**re: Grading Plan Review**  
**Proposed Apartment Building**  
3080 Navan Road – Ottawa, Ontario

**date: May 3, 2024**

**file: PG6527-MEMO.01 Revision 2**

- Grading Plan – 3080 Navan Road (Rhythm Apartments), City of Ottawa – Project No. 122180 – Drawing No. 122180-GR Revision 5, dated April 22, 2024.

LOCATION:
 CITY OF OTTAWA
 3080 NAVAN ROAD (RHYTHM APARTMENTS)

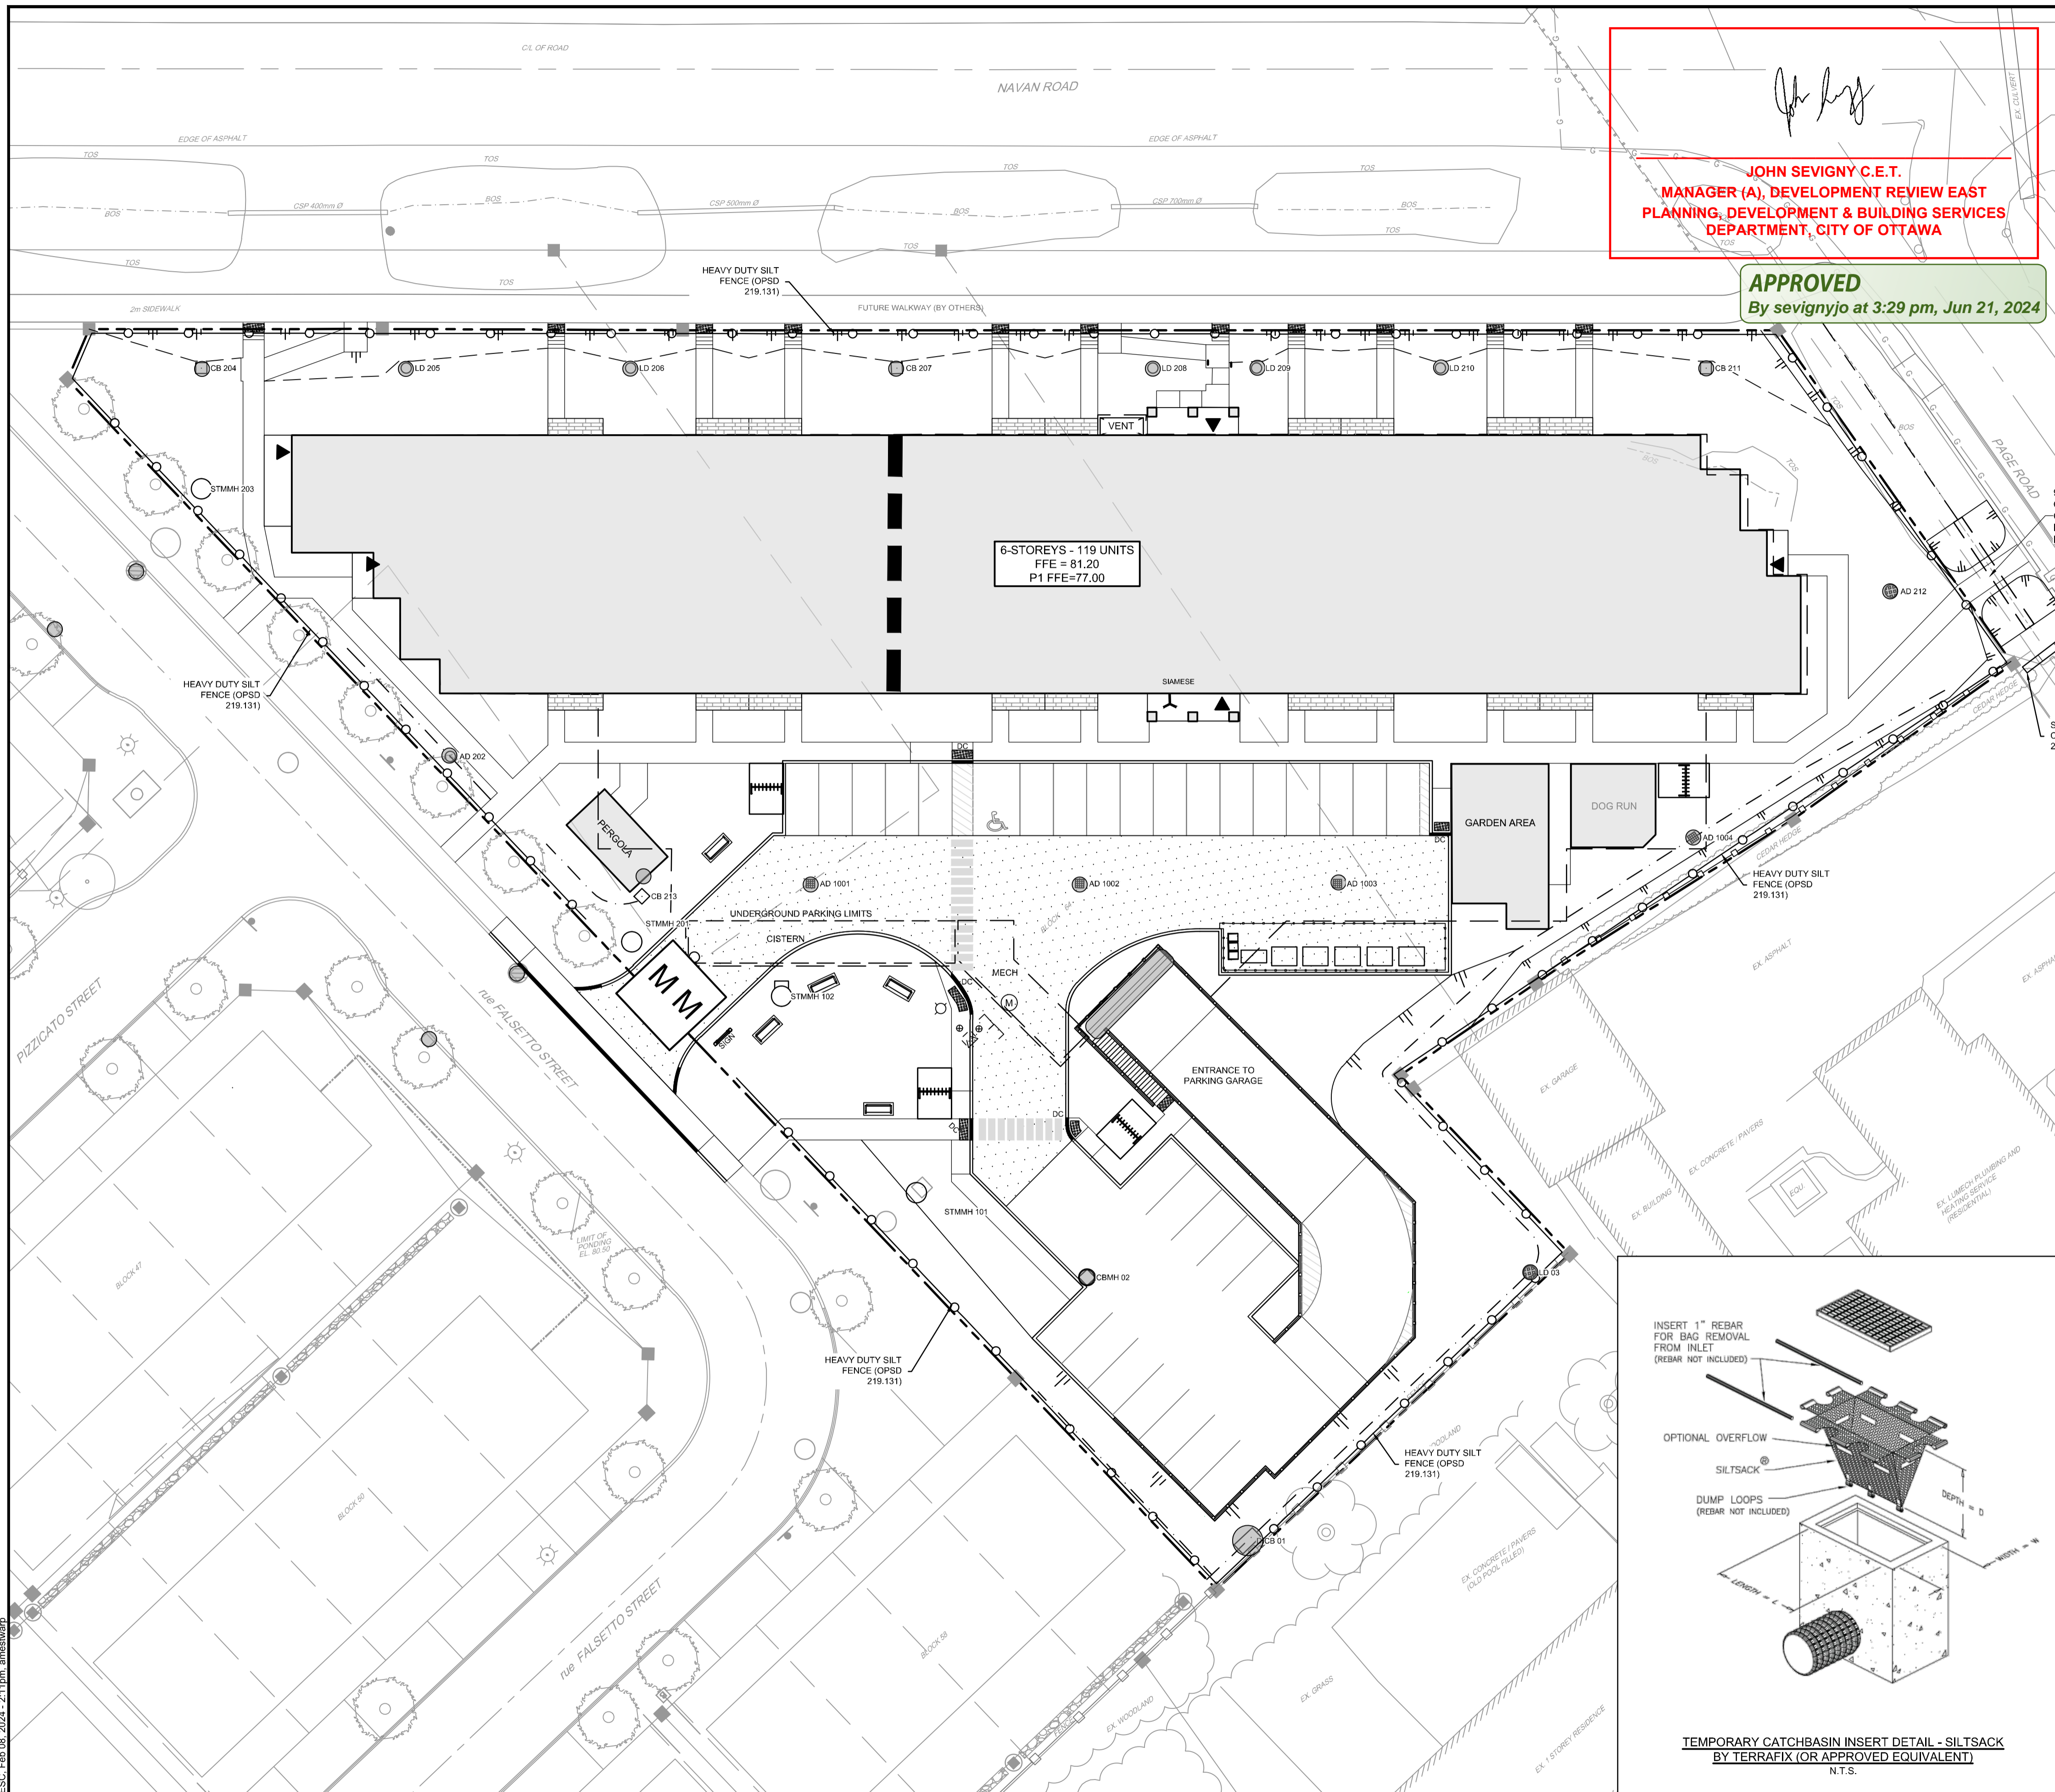
Based on the grading plans provided, the proposed grading throughout the majority of the subject site is within the permissible grade raise recommendations provided in the aforementioned geotechnical report.

However, in the north corner of the site, grade raise exceedances of up to approximately 0.5 m are currently proposed for the landscaped and hardscaped areas located within 5m of the building footprint. Where these grade raise exceedances are proposed, lightweight fill (LWF) is recommended to mitigate excessive settlement. The attached figure PG6527-Figure 1 – Lightweight Fill Recommendations indicates the approximate LWF locations and thicknesses which are recommended.

Overall, the LWF should consist of EPS (expanded polystyrene) geofoam blocks, which allow for raising the grade without adding a significant load to the underlying soils. For this application, EPS Type 15 should be used and extended a minimum of 5 m beyond the building footprint in all directions where it is being recommended to be used.

It should also be noted that EPS is difficult to use under the groundwater level, as it is buoyant, and it must be protected against potential hydrocarbon spills. Based on this, the placement of lightweight fill should be planned to provide a minimum of 1.5 m of backfill upon its surface. The lightweight fill layer is recommended to be placed a minimum of 500 mm above any perimeter drainage sleeves/pipes provided to the main building structures foundation and the associated open-graded stone layers.

The lightweight fill should be placed upon a flat soil surface. Therefore, the soil should be compacted to be relatively smooth and flat prior to installation. Consideration may be given to placing a thin layer of sand or stone dust to attain a relatively smooth/flat surface for placement. The entire lightweight fill layer footprint is recommended to be covered with a layer of polyethylene (taped at seams) extending between the building footprint and outer edge of the layer and extending below its surface by a minimum of 100 mm at all edges of the lightweight fill layer.

If the lightweight fill will be located in an area of landscaping, the placement of the layer should be planned to provide a minimum 500 mm of soil cover be provided to the lightweight fill layer for grass and associated vegetation can establish overtop the lightweight fill.

The placement of all lightweight fill should be reviewed at the time of placement by Paterson personnel. It is also advised a brief pre-construction meeting to be held between Paterson and the construction team to discuss placement prior to the installation. As an alternative to the use of LWF, the areas of the proposed grade raise exceedances could be preloaded to the finished grade, or surcharged, using fill materials. This option, however, would require allowing an extensive period of time for the settlement to occur prior to construction, which may not be compatible with construction timelines. Additional information can be provided if this option is being given consideration.
